Addendum No. 1

RE: Contract # C204149

Halifax County (R-3822, U-5725)

NC-125 From I-95 To Old Farm Road South; SR-1627 (Three Bridge Road)

NAD 83 / NA 2011

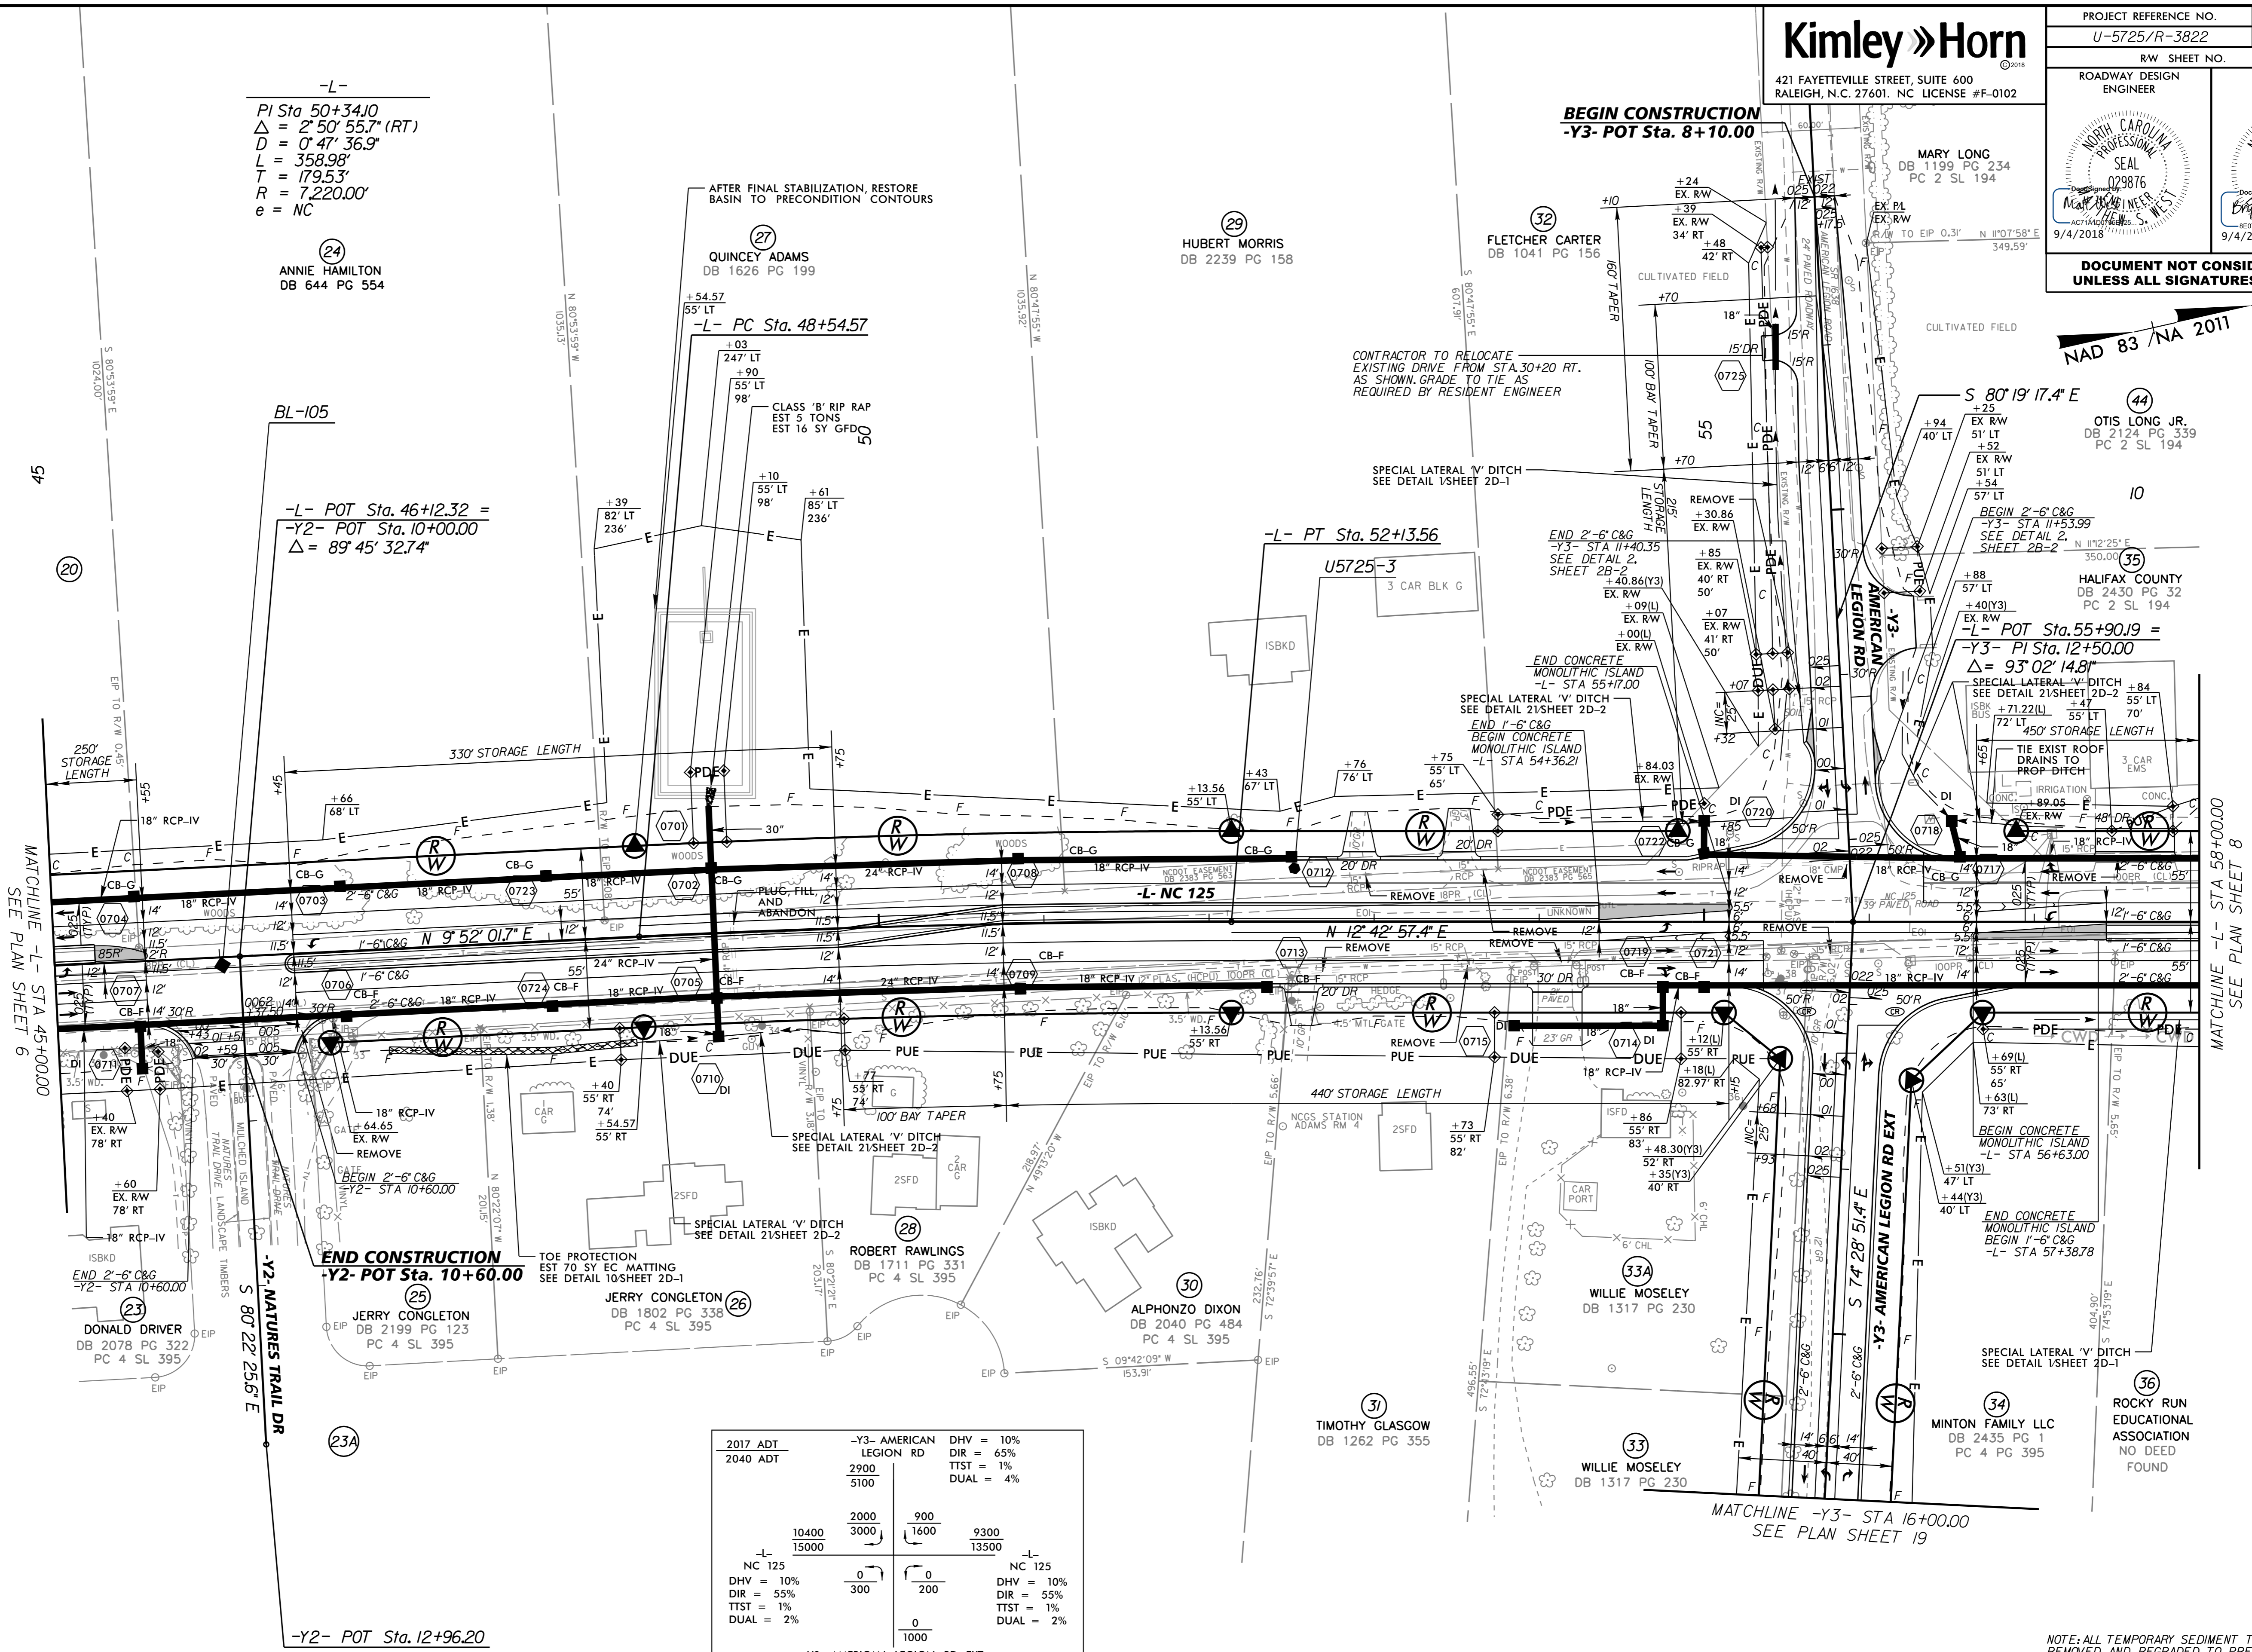
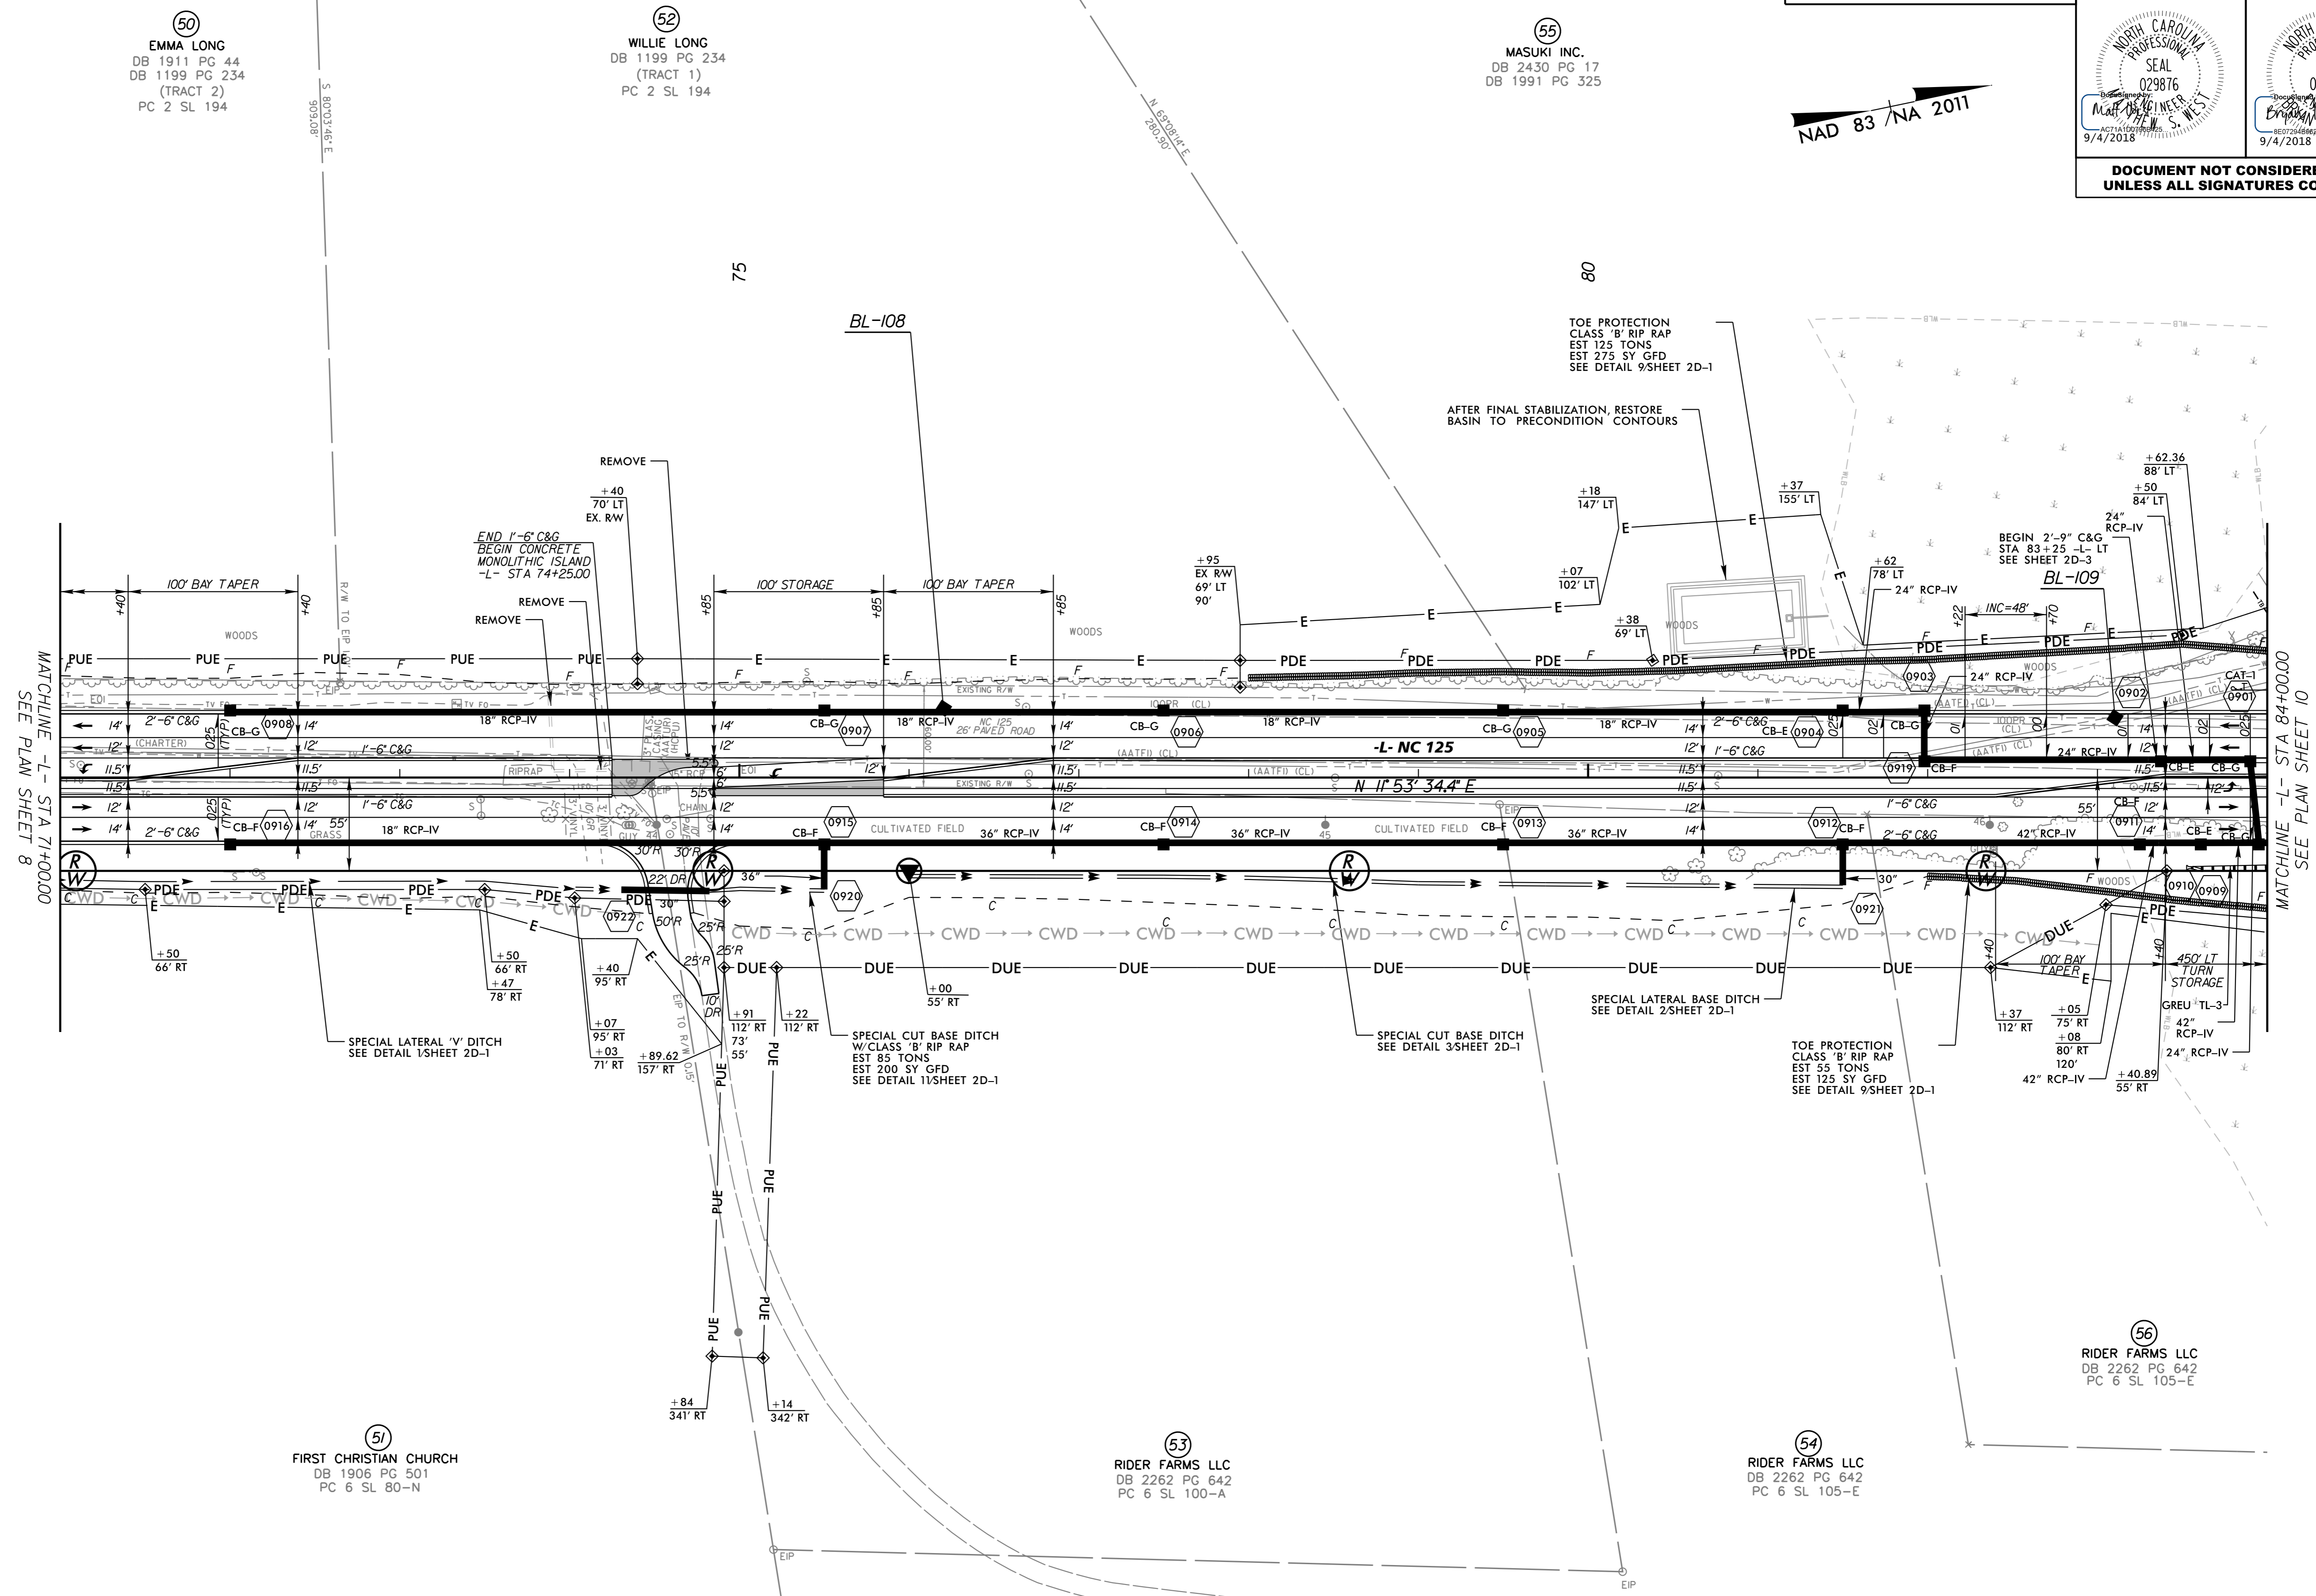
Sheet No.	Revisions
4 thru 19	Revised Right of Way and Easement notes for some callouts. Right of Way and easement lines have not changed
